From: Phil Wiltshire [REDACTED]
Sent: 04 November 2015 11:07
To: David Easton
Cc: [REDACTED]
Subject: RE: AW/267/15/HH - 68 The Drive, Aldwick

Subject: FW: AW/267/15/HH - 68 The Drive, Aldwick

From: David Easton [REDACTED]
Sent: 03 November 2015 09:23
To: Phil Wiltshire [REDACTED]
Subject: AW/267/15/HH - 68 The Drive, Aldwick

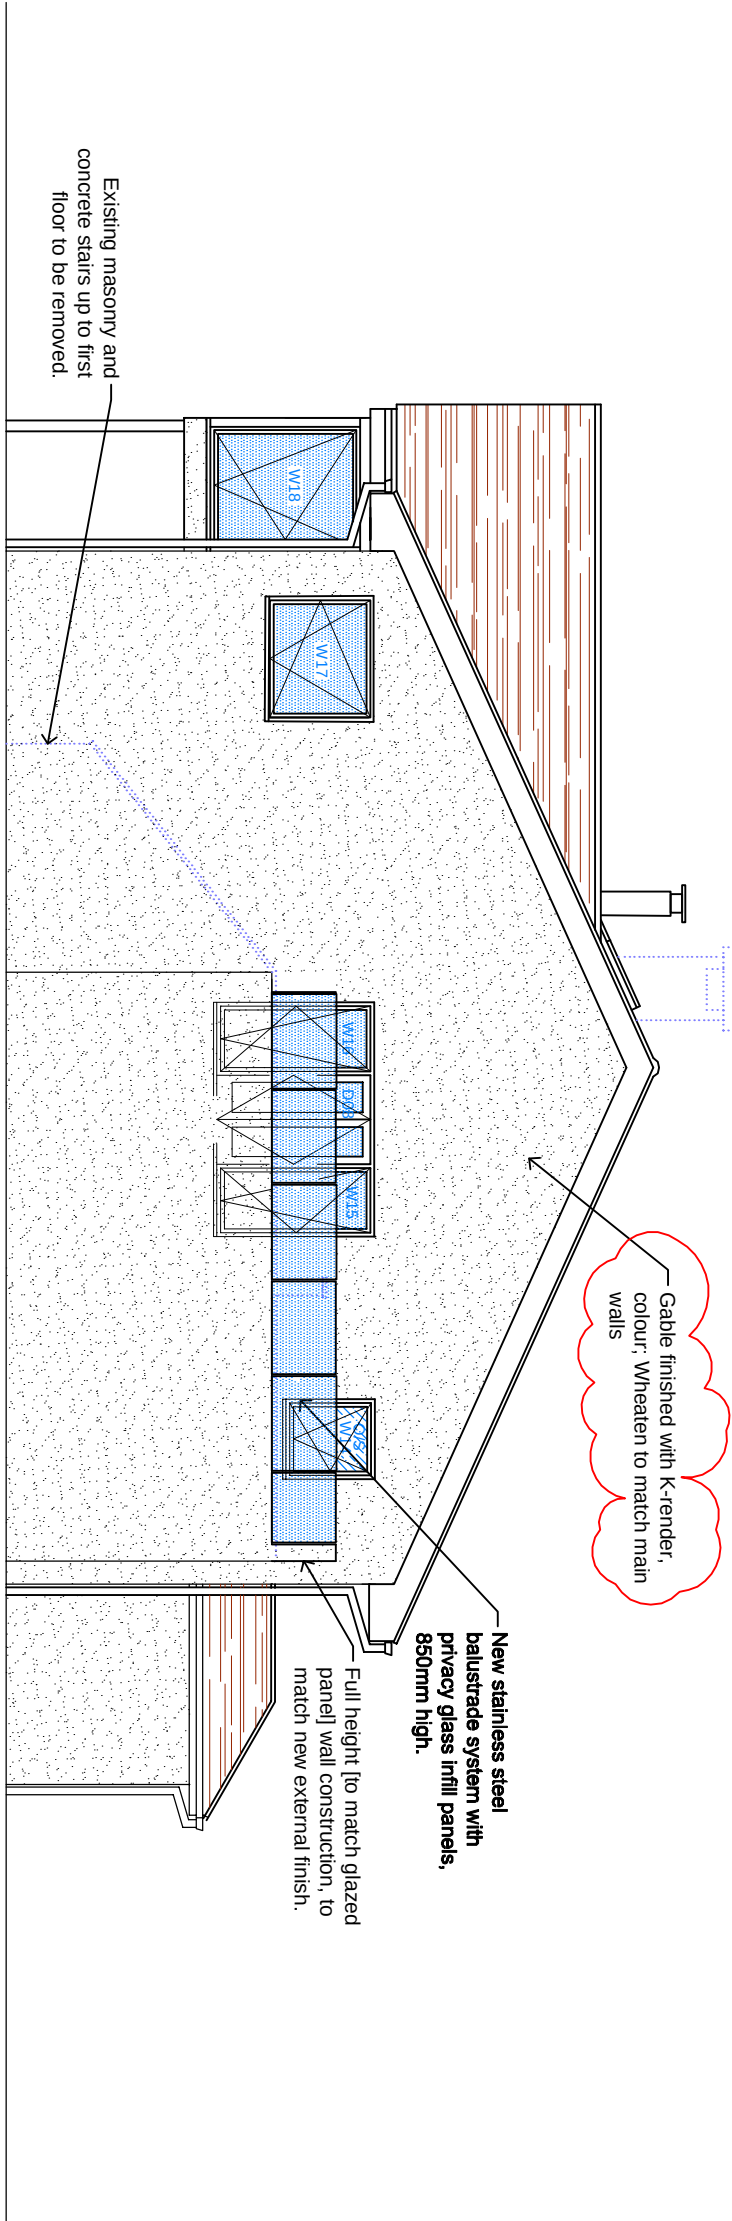
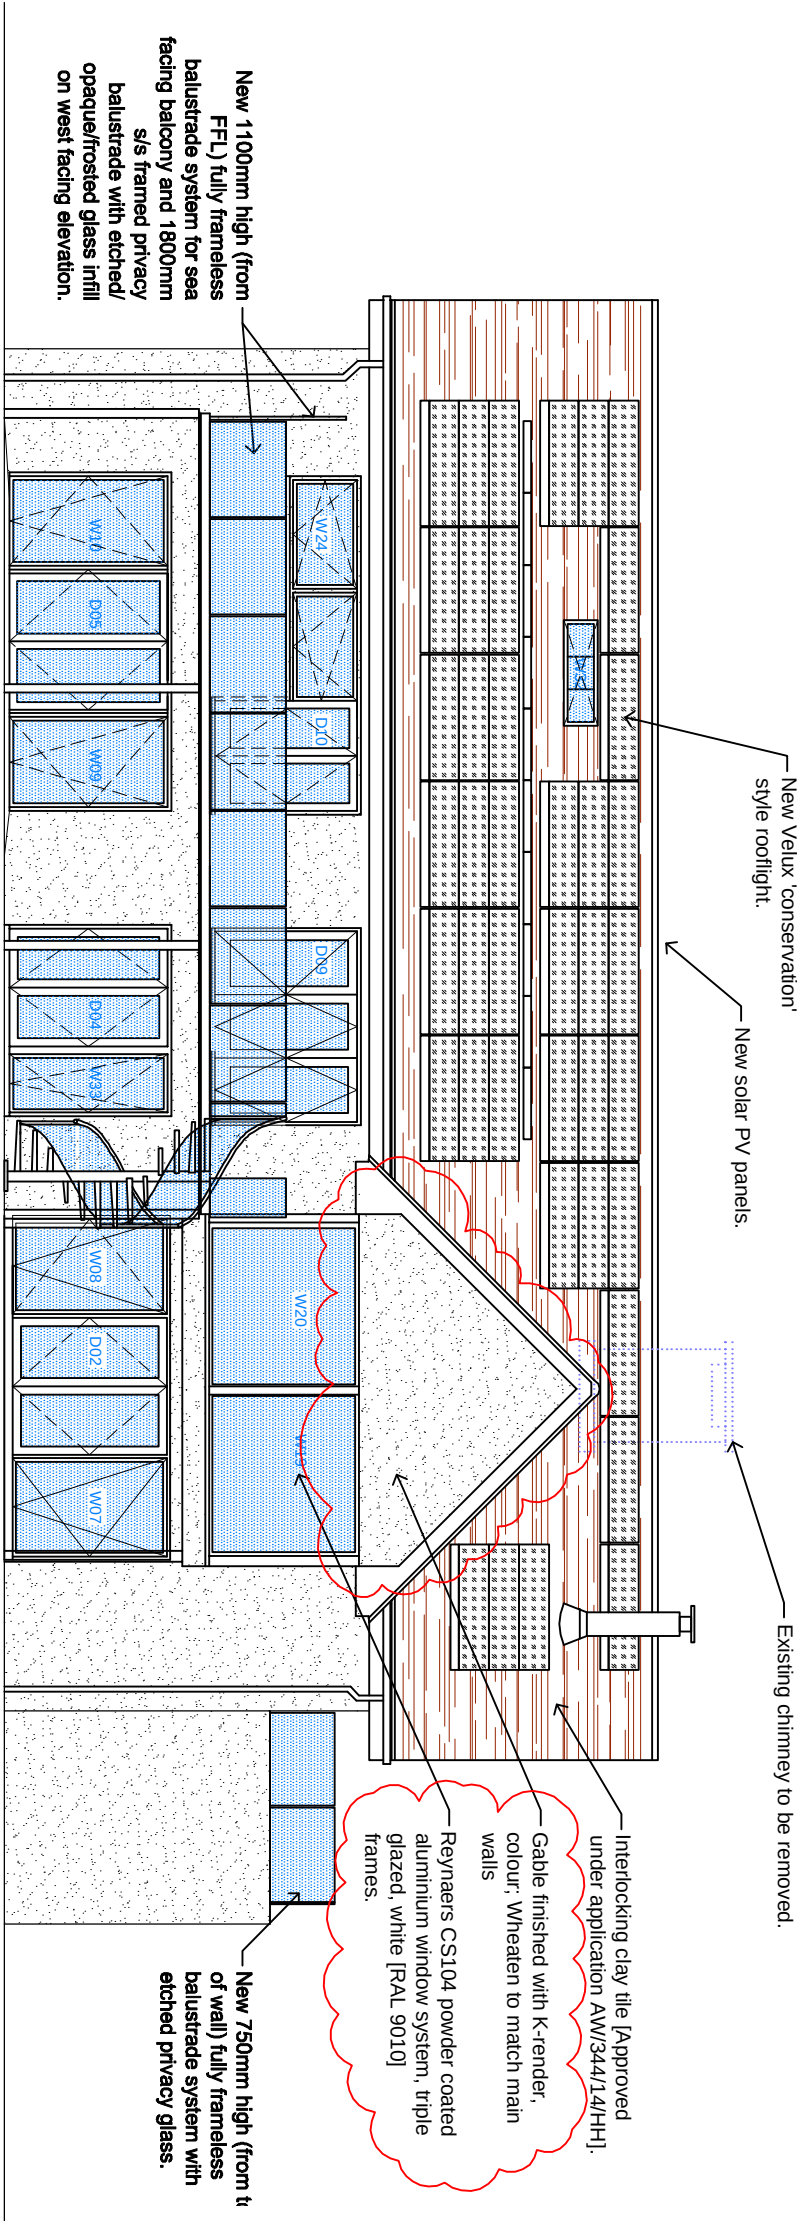
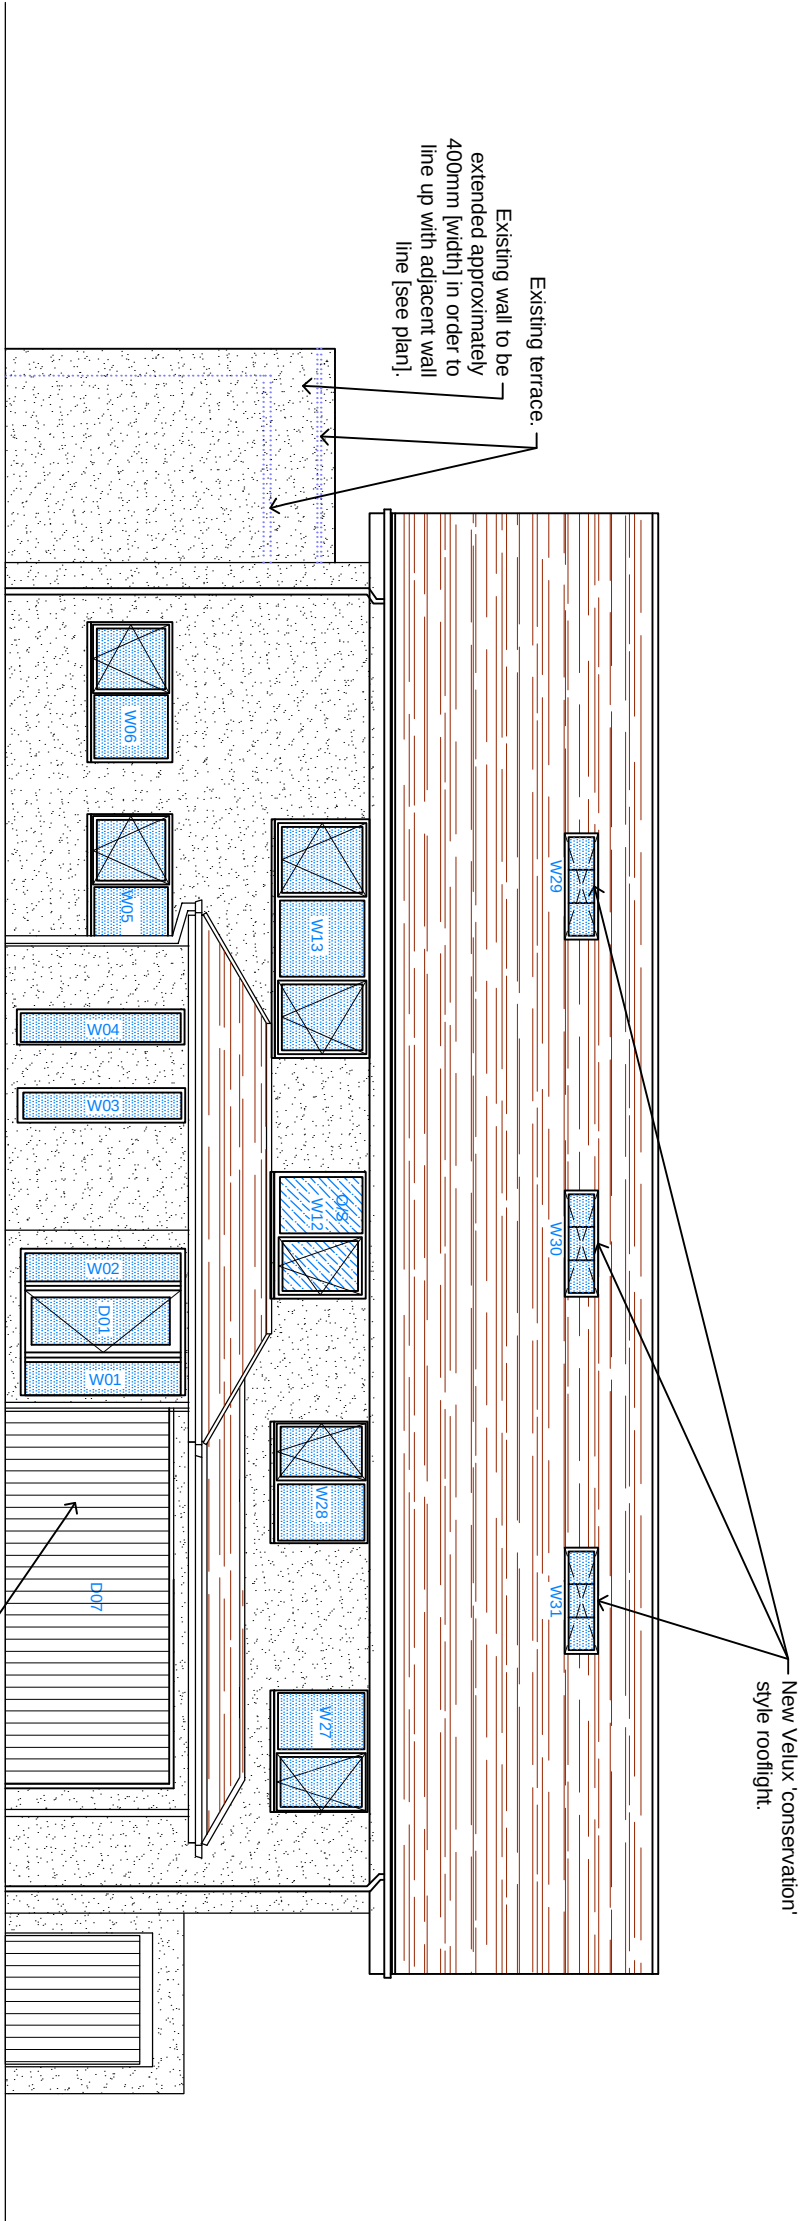
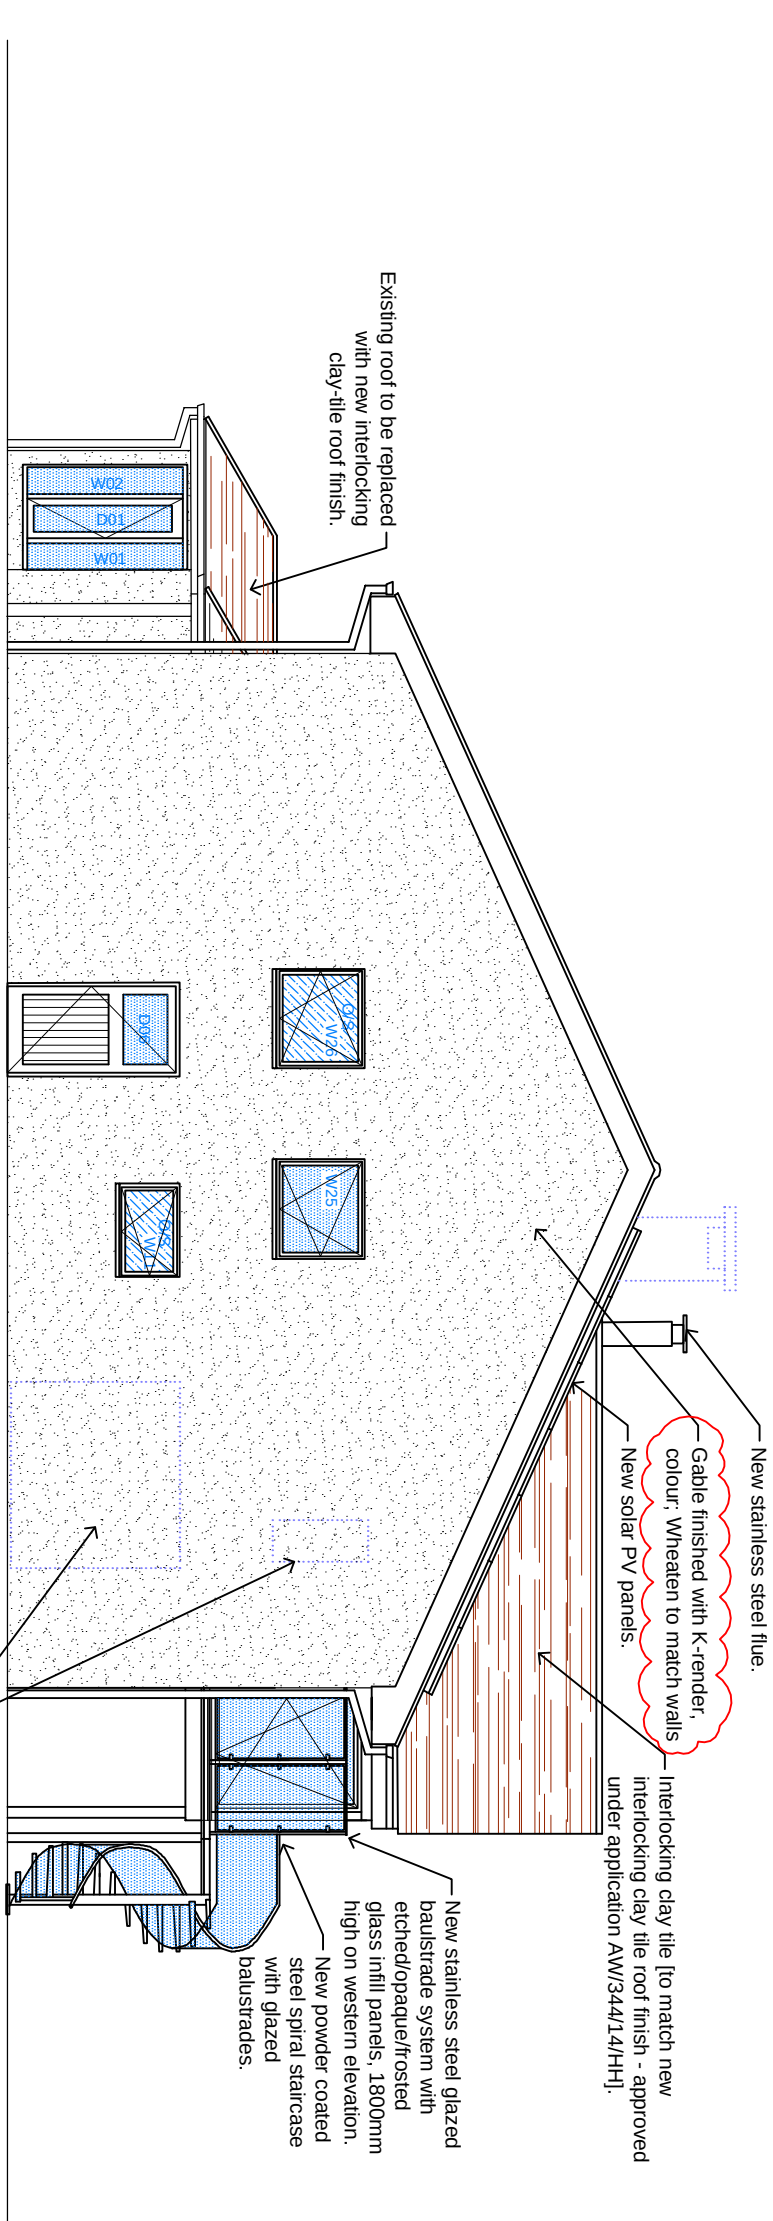
- the downlights in the soffits
- the colour of the windows
- the weatherboarding

I attach our amended planning drawing PL1 rev D to reflect the following changes;

- Omission of the soffit led lighting (although we note that similar lighting is provided on other properties within the conservation area)
- Omission of the Eternit cladding to the main gables and southern gable
- Change from grey aluminium window and door frames to white

To facilitate these changes we have also shown a slight change of the render colour from the original approved colour of Limestone White to Wheaton noting the colour swatches are provided within appendix 13.2 as our original design statement.

Our clients have also requested if the external spiral stairs can be relocated slightly further westwards so its more central along the south elevation and we have undertaken some minor alterations to the window opening arrangements which are included in this drawing.
